CITY OF ALBUQUERQUE

**RE: Main Event, Albuquerque Carpenters Training Center (File: G16-D149)
4040 Pan American Freeway NE 87107
Grading Plan and Drainage Plan, Engineer's Stamp Date 5-27-2015
Engineer's Certification Dated 5-27-16 and 6-6-16**

**RE: Main Event, Albuquerque Carpenters Training Center (File: G16-D149)
4040 Pan American Freeway NE 87107
Interim Grading Plan and Drainage Plan, Engineer's Stamp Date 5-27-2015**

MAIN EVENT		DRAWN BY
PAN AM FREEWAY AND VASSAR AV.		BJF
GRADING PLAN		DATE
		05/14/15
		2015015-GRB
		SHEET #
<b>TIERRA WEST, LLC</b> 5571 MIDWAY PARK PLACE NE ALBUQUERQUE, NM 87109 (505) 858-3100 www.tierrawestllc.com		<b>C5</b>
		JOB #
		2015015

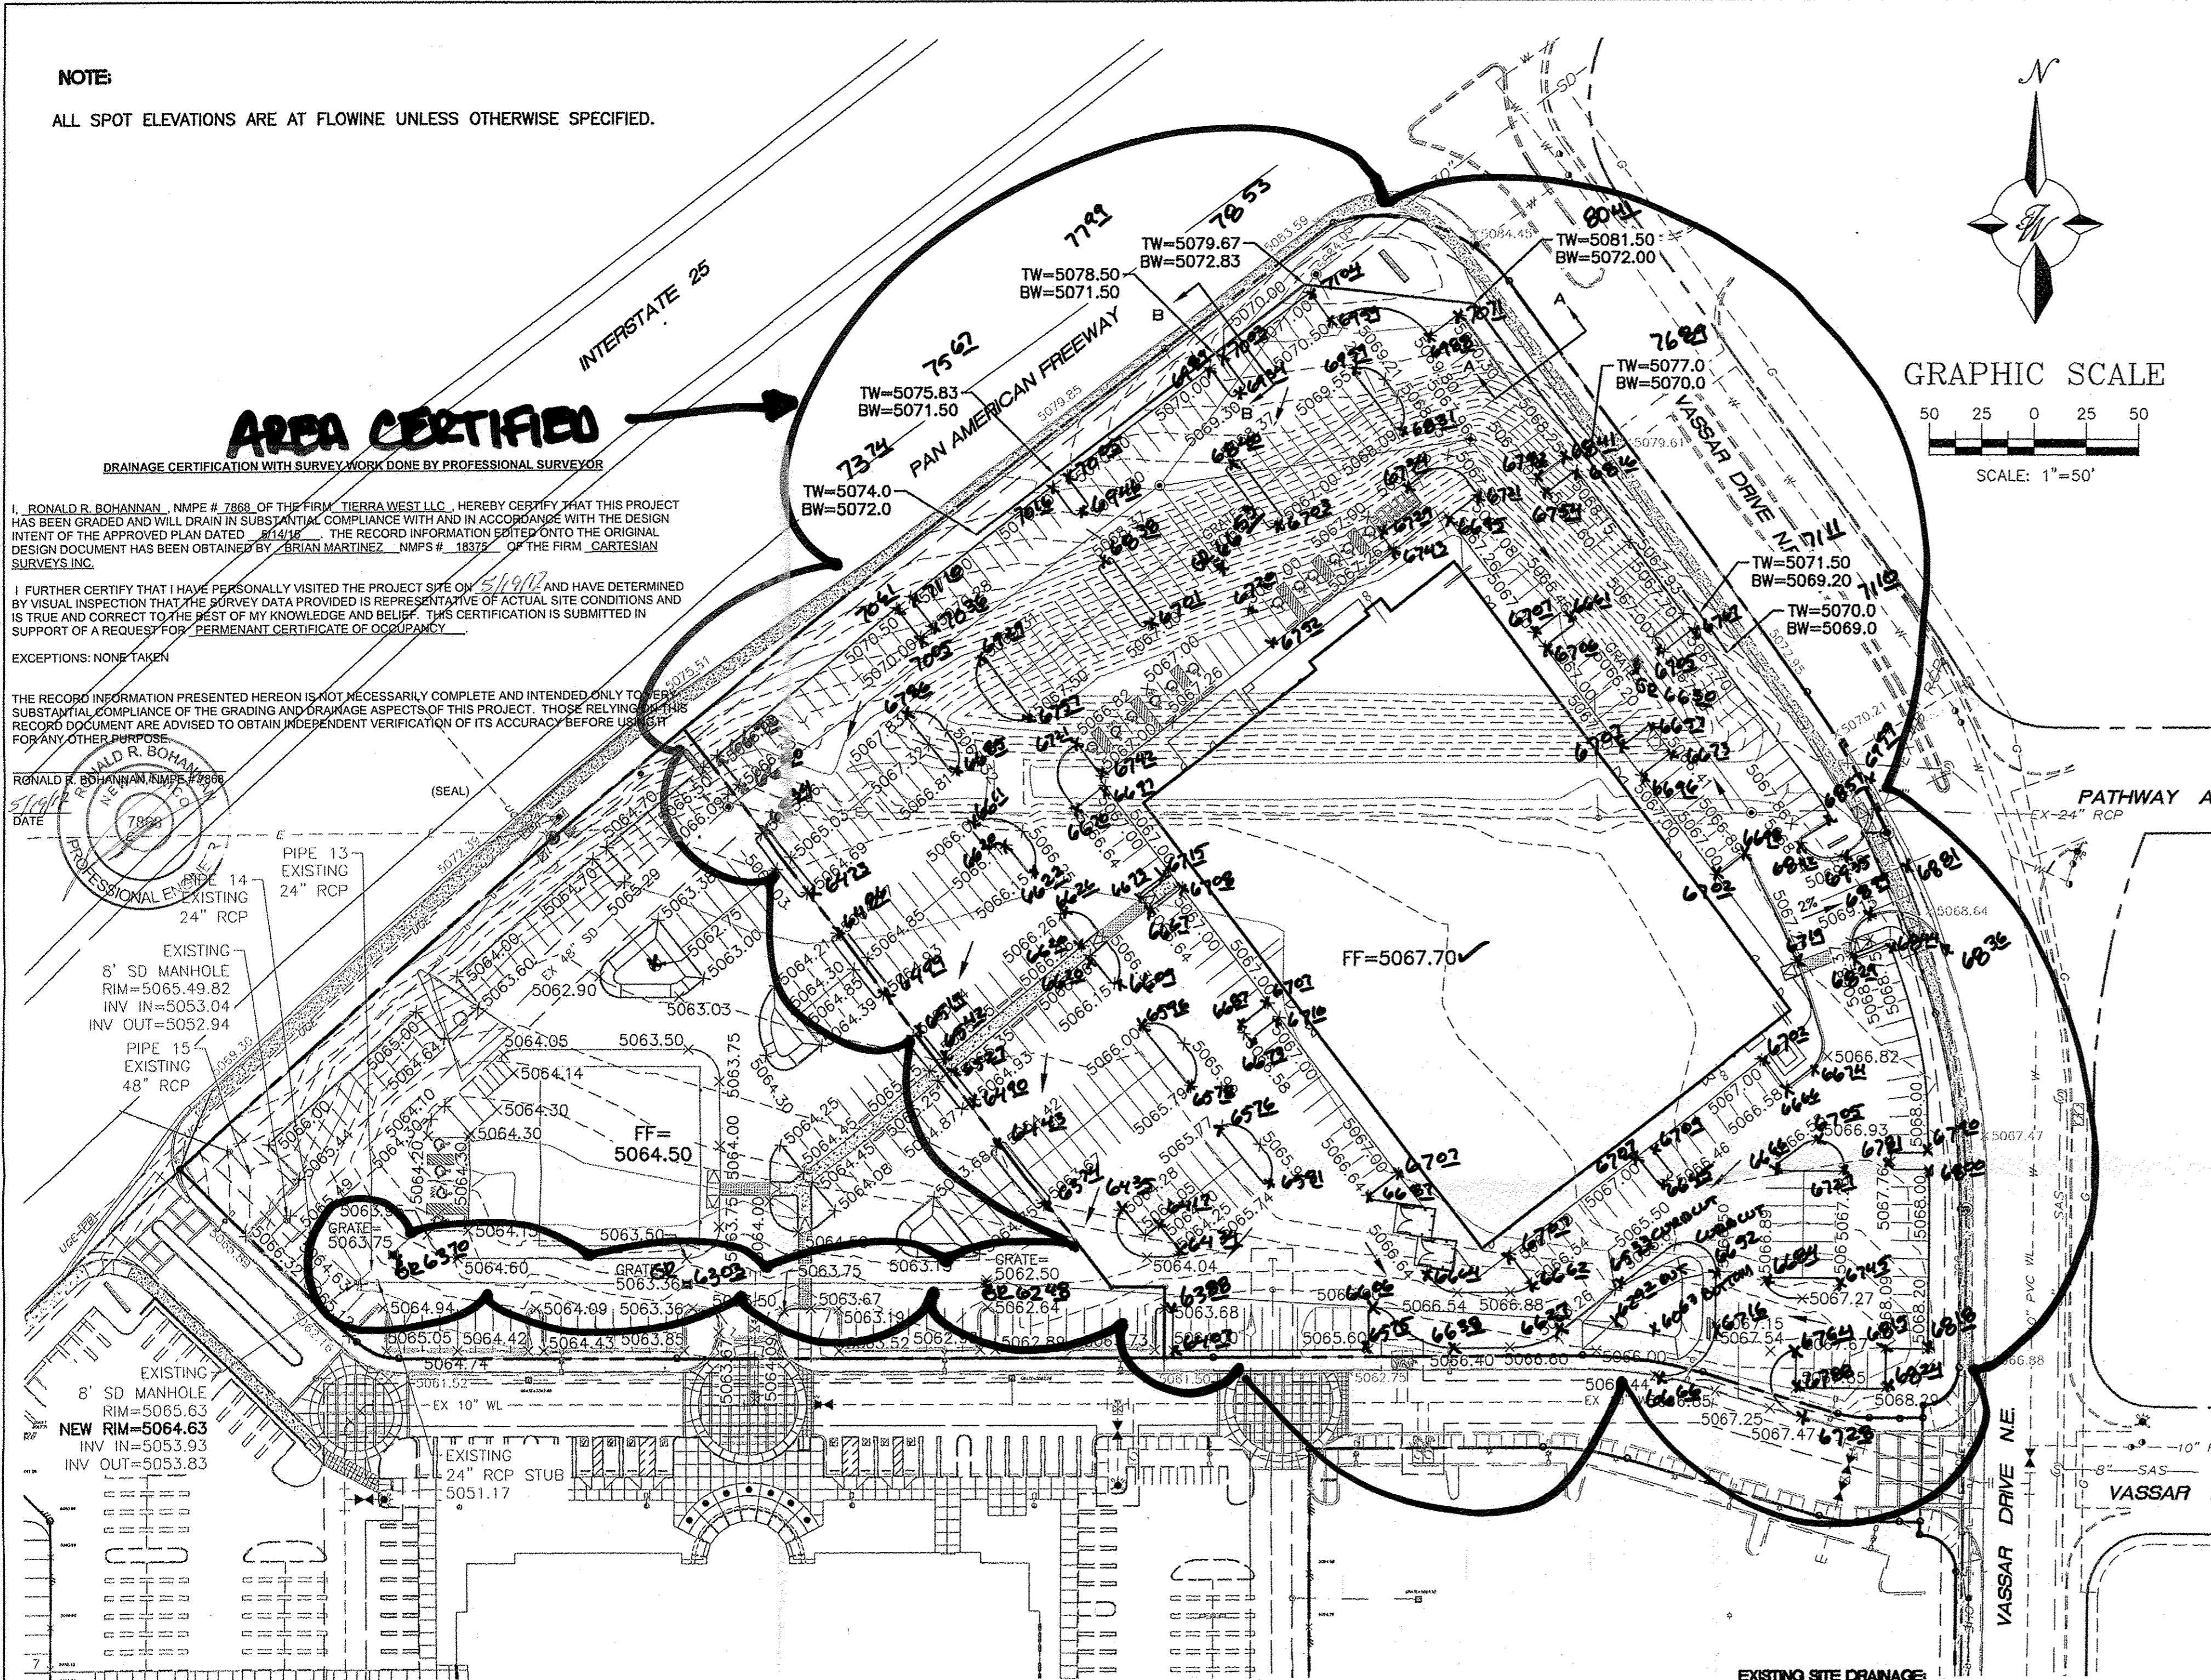
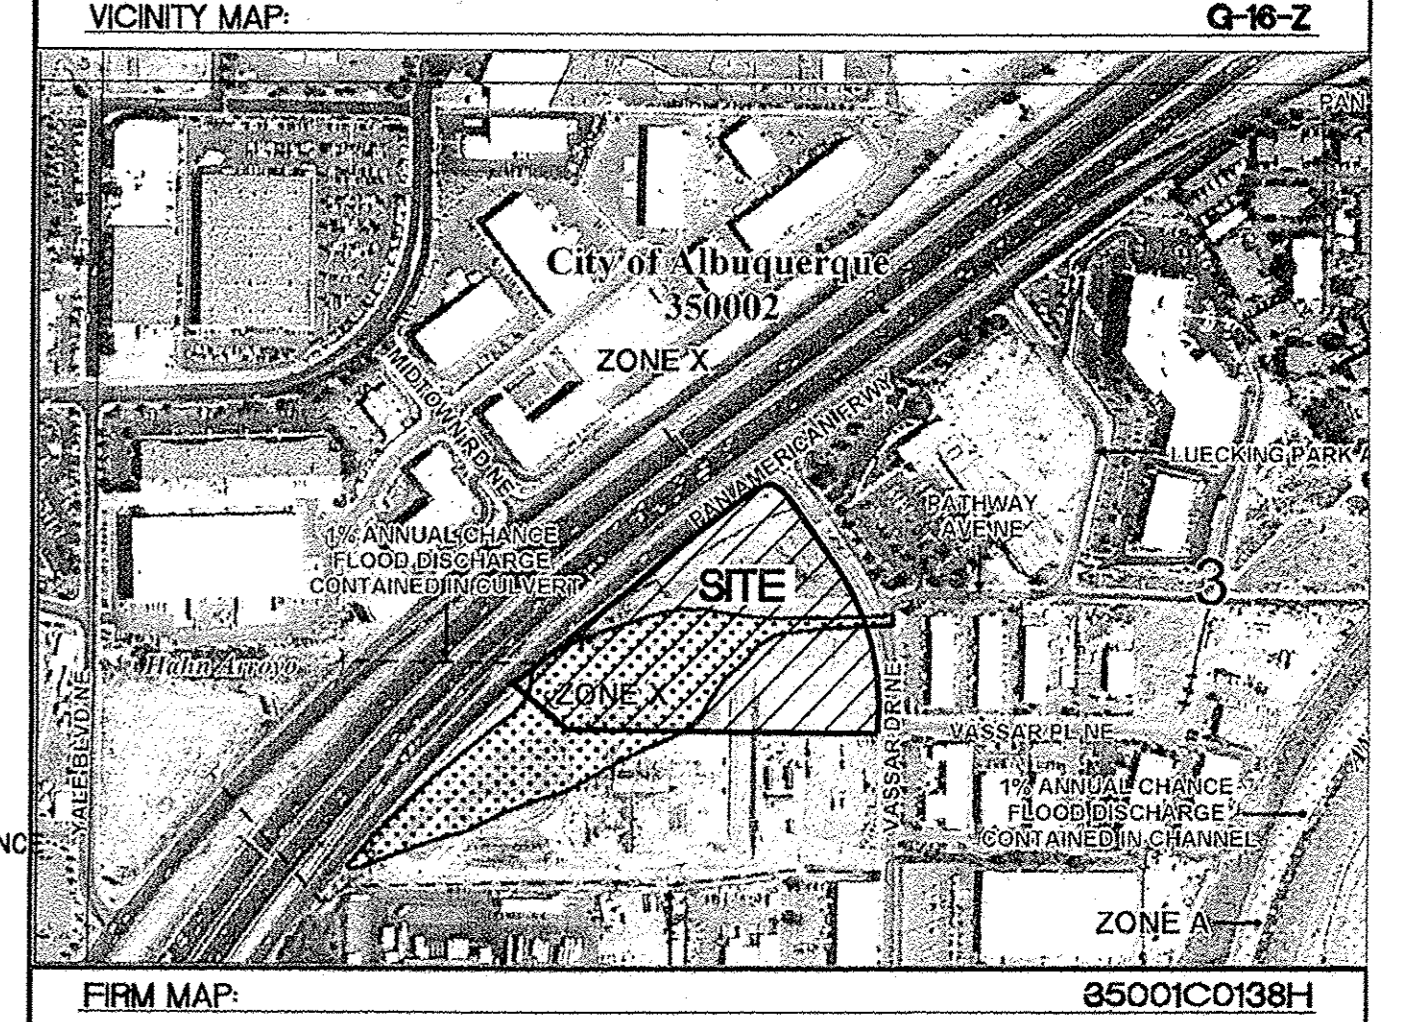
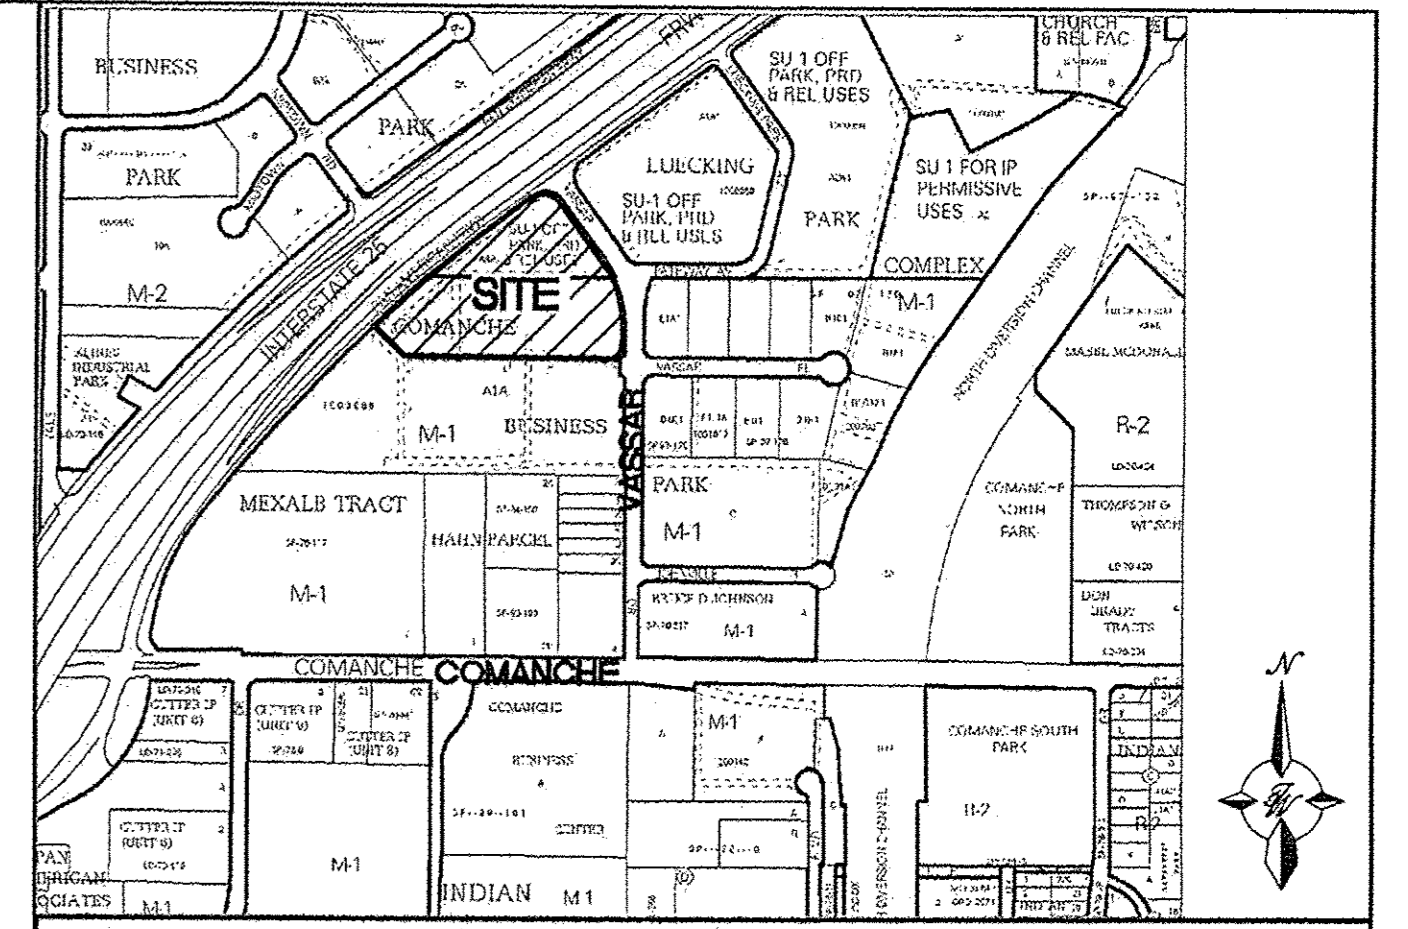
- 1) Pond 1 needs a drainage swale and riprap along the edge where water enters. I discussed this with the Superintendent.
- 2) Inlets located in the undeveloped lot need to have shallow ponds dug around them. They need to have a min. radius of 5' from the inlet, and 1' deep. They must be lined with riprap. This was also discussed with the superintendent.

The Engineer's cert for Permanent CO was to have these items shown on the as-built, and this would have sufficed in lieu of an interim grading plan. However, the Eng. Cert I received does not show either of these . I also listed in in Comment #2 of my letter (see attached).

I hope you agree that the improvements I asked of the superintendent were acceptable in handling the interim drainage. I normally would not have tried to resolve the interim drainage issue as I am not the Engineer of Record, but in order to give a Temp CO, I had to make some quick decisions. If you agree with how it was resolved, then show the improvements on the Eng.Certified plan. Otherwise, have the contractor make whatever changes you deem necessary and show those on the Eng. Cert. plan.

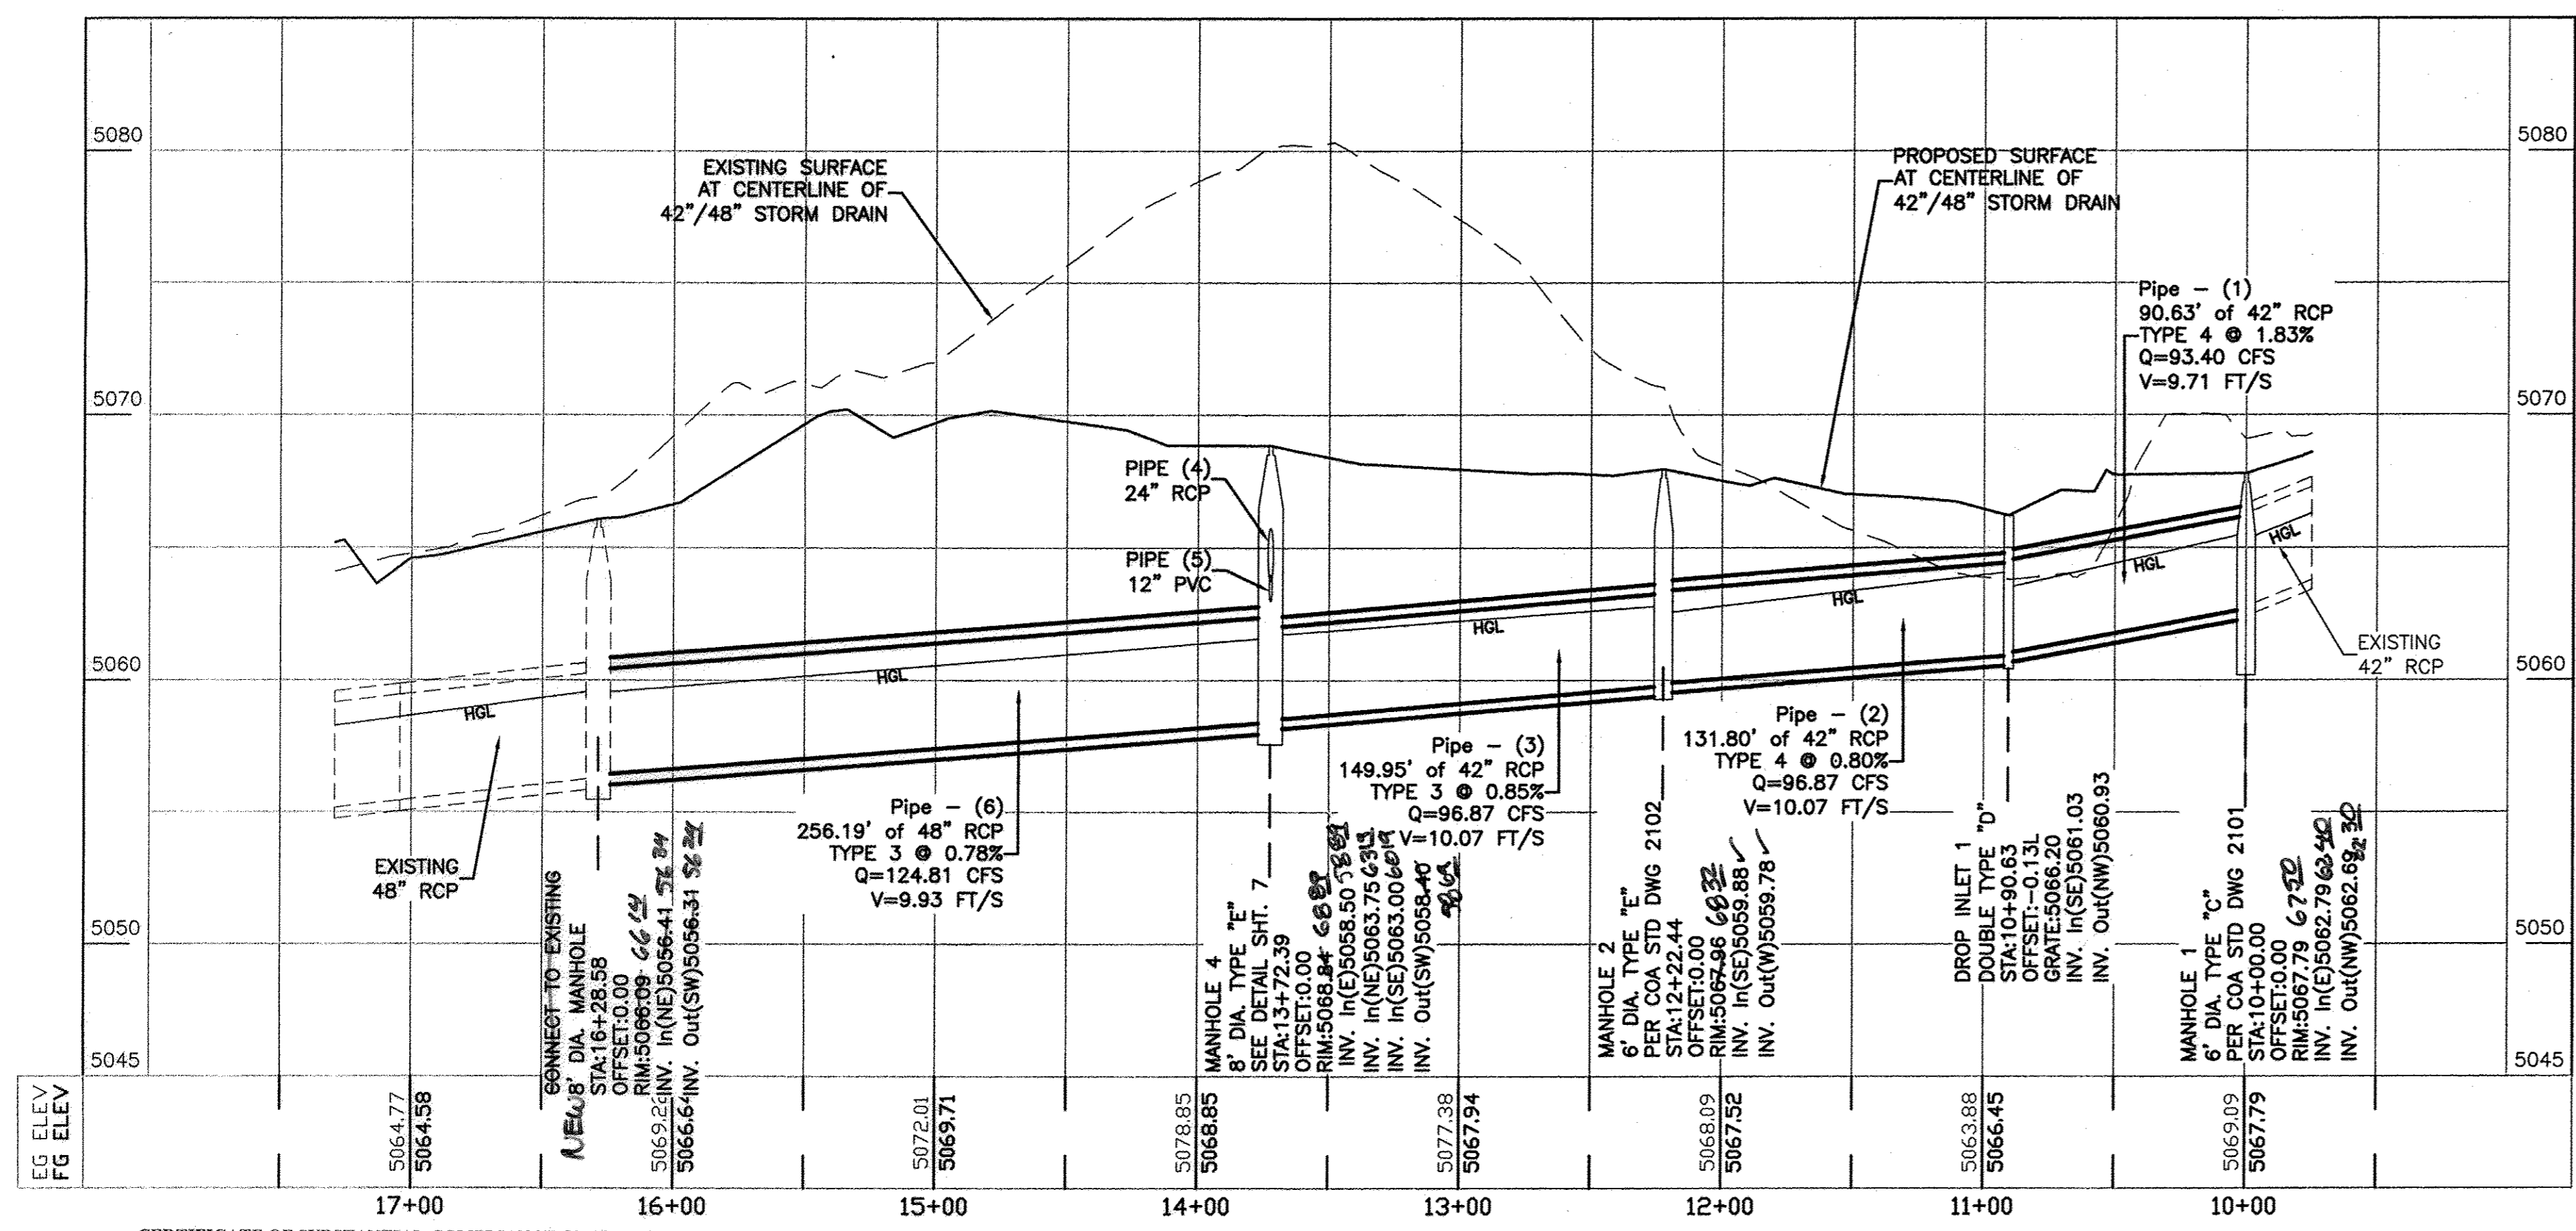
1. Drainage Plan, Sheet C6 must be Certified. All private Storm Drain improvements must be as-built and certified on this sheet.
2. Permanent ponds must be as-built and certified. Additionally, the interim sediment ponds that were to be built around the inlets on the undeveloped lot must also be certified. Curb-cuts need to be also shown on the as-built.
3. The Work-order for the Public Storm Drain has punch list items. Either the work- order must be accepted, or the punch list items completed:
 - Grout I-beam at modified double "D" inlet on Vassar Dr
 - Clip corner of concrete SD collar and remove excess concrete from SDMH at NW corner of site.
 - Grout MH barrel joints at NW corner of site.
